WEST SUSSEX COUNTY COUNCIL CONSULTATION

TO:	Arun District Council FAO: Simon Davis
FROM:	WSCC - Highways Authority
DATE:	17 March 2021
LOCATION:	North Barn Hoe Lane Flansham PO22 8NT
SUBJECT:	Y/22/21/PL Change of use from existing open barn to 1 No. dwelling (C3 Dwelling House), refurbishment & single storey extension to North elevation (renewal of permission Y/60/16/PL, amended with Y/53/19/NMA). This site is in CIL Zone 3 and is CIL Liable as new dwelling & may affect the setting of a listed building.
DATE OF SITE VISIT:	n/a
RECOMMENDATION:	Advice
S106 CONTRIBUTION TOTAL:	n/a

Drawing P02 January 2021 Scale 1:20 & 1:100 @ A3
Proposed Drawing - Site Plan & Fence Details

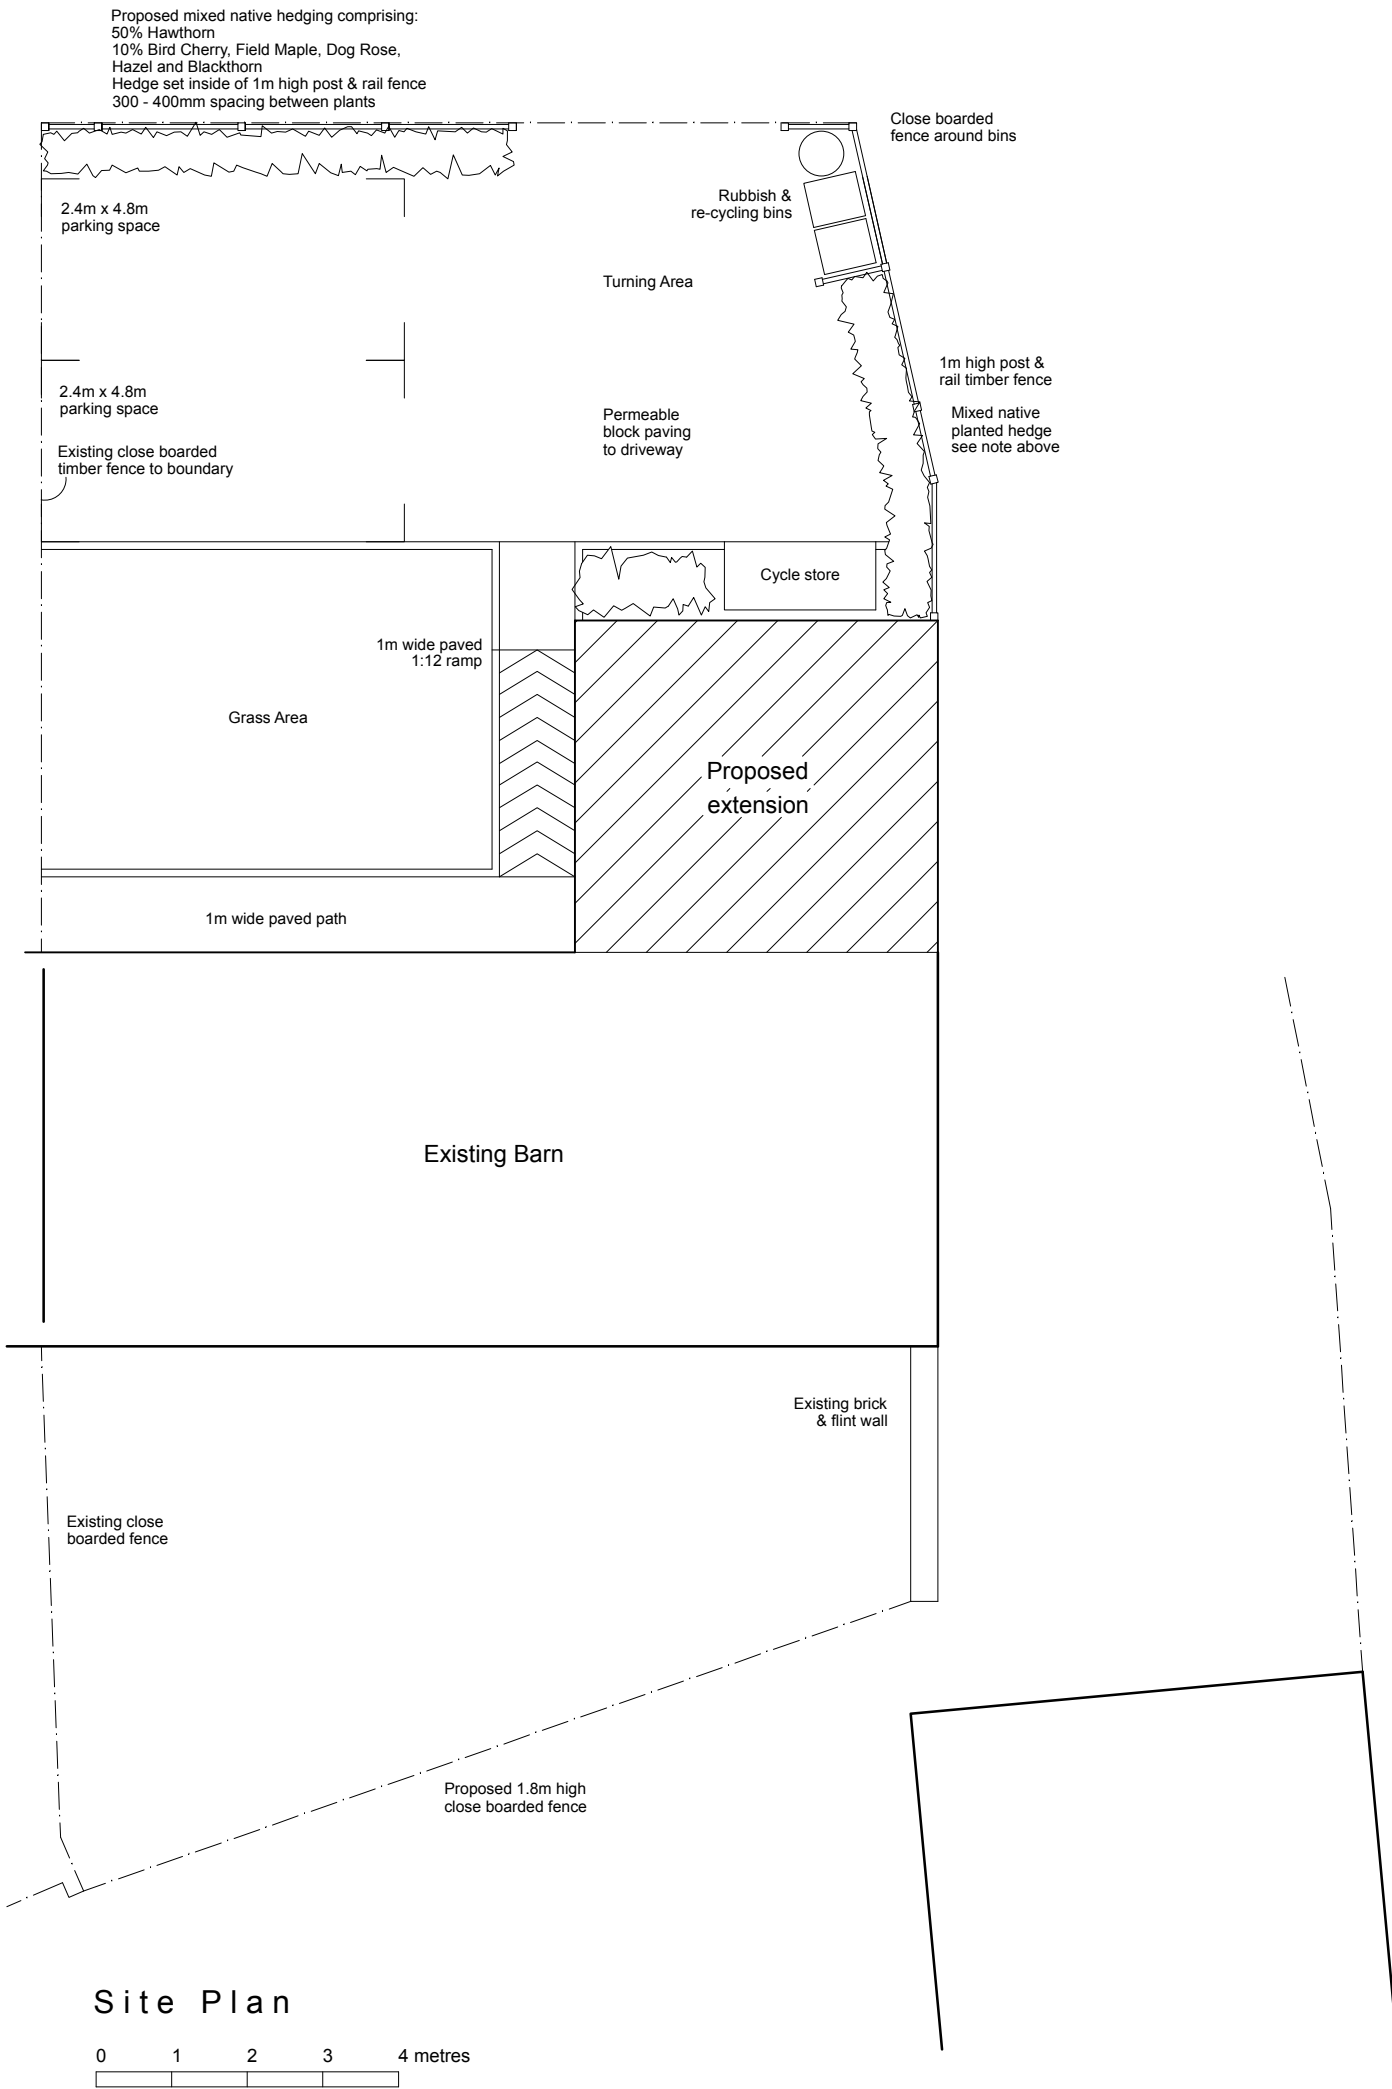
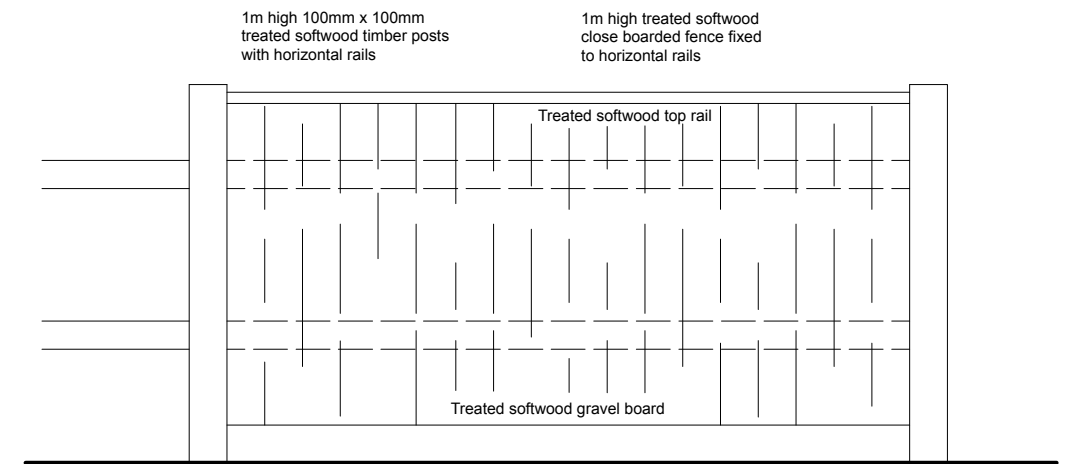
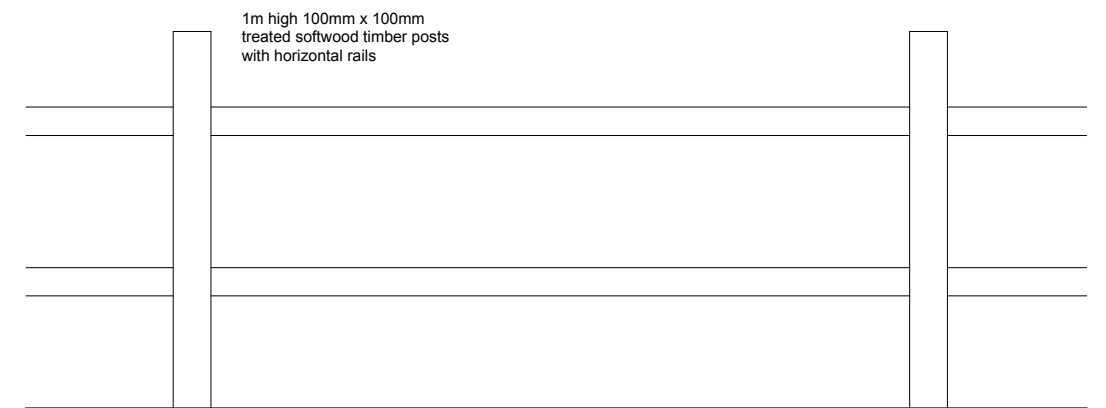
The dwelling will utilise the existing access via Hoe Lane. A parking area for two cars has been included within the curtilage of the site with an opening on to the private forecourt area approximately 5 m wide. This is sufficient for a car to pass through.

There appears to be sufficient space for parking and turning on site. The WSCC Car Parking Demand Calculator envisions that a development of this size and location should be provided with two car parking spaces therefore the LHA are satisfied that parking provision has been met. There have been no recorded collisions within the past three years in the vicinity and it is not envisioned that the change of use would exacerbate any existing safety concern.

The site is rural in nature and does not benefit from street lit footways. There are limited retail and other amenities within the vicinity such as a local farm shop. However, the nearest bus stop is 5 minute walk distant on the A259 which provides services on to Gatwick and Littlehampton. Cycling would be an attractive mode of sustainable transport in this location and the applicant has provided a separate cycle storage shed within the curtilage of the site. This should be kept in perpetuity.

No part of the development shall be first occupied until the vehicle parking and turning spaces have been constructed in accordance with the approved plan. These spaces shall thereafter be retained for their designated use.

No part of the development shall be first occupied until covered and secure cycle parking spaces have been provided in accordance with plans and details to be submitted to and approved by the Local Planning Authority.
